Validation ESHER number 202115

Address: St Andrew's Church Bishopstone, BN25 2UD

Proposal: demolition of the underground boiler house and the proposed new extension.

SDNP/24/00345/FUL. St Andrew's Church Bishopstone, BN25 2UD

Fig. 24: Excavation Plan and Proposed Sewer
Adapted from Thomas, 2010

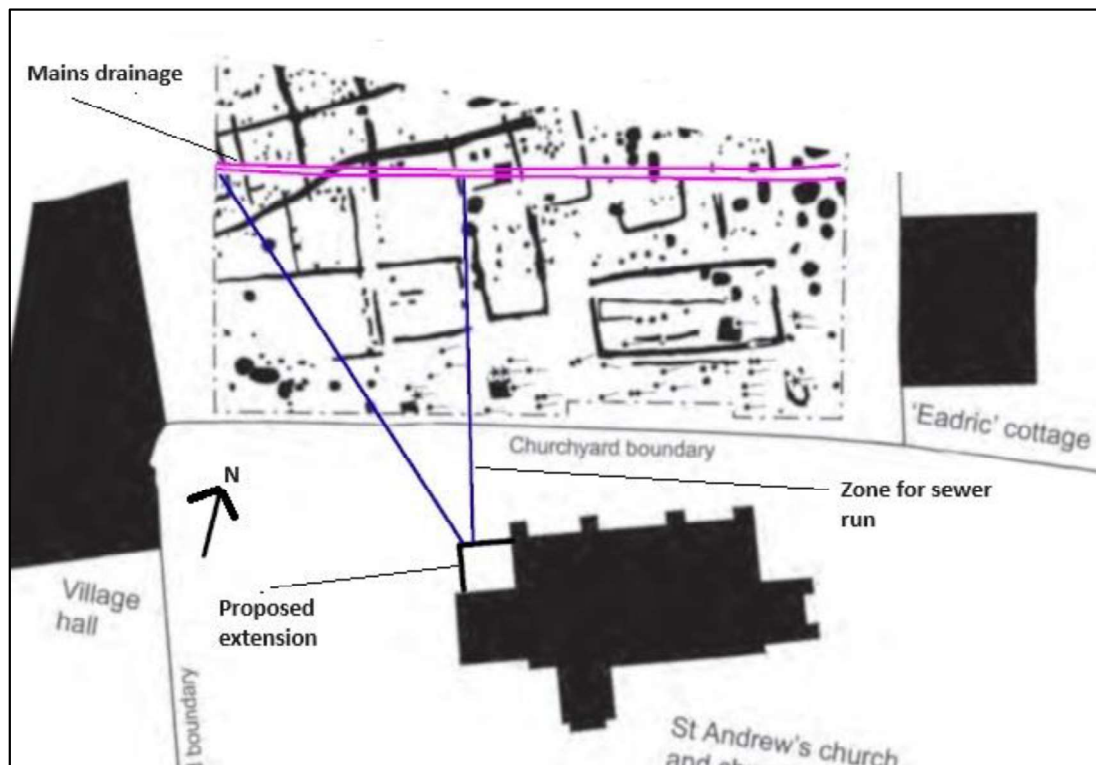
illustrating all impacts better (in particular in relation the evidence of the Anglo-Saxon settlement beneath the village green where the new drain connection is proposed).

within/without the existing churchyard and factoring in the evidence identified in the churchyard. Please illustrate the full extent of the drain run to link to the existing sewer).
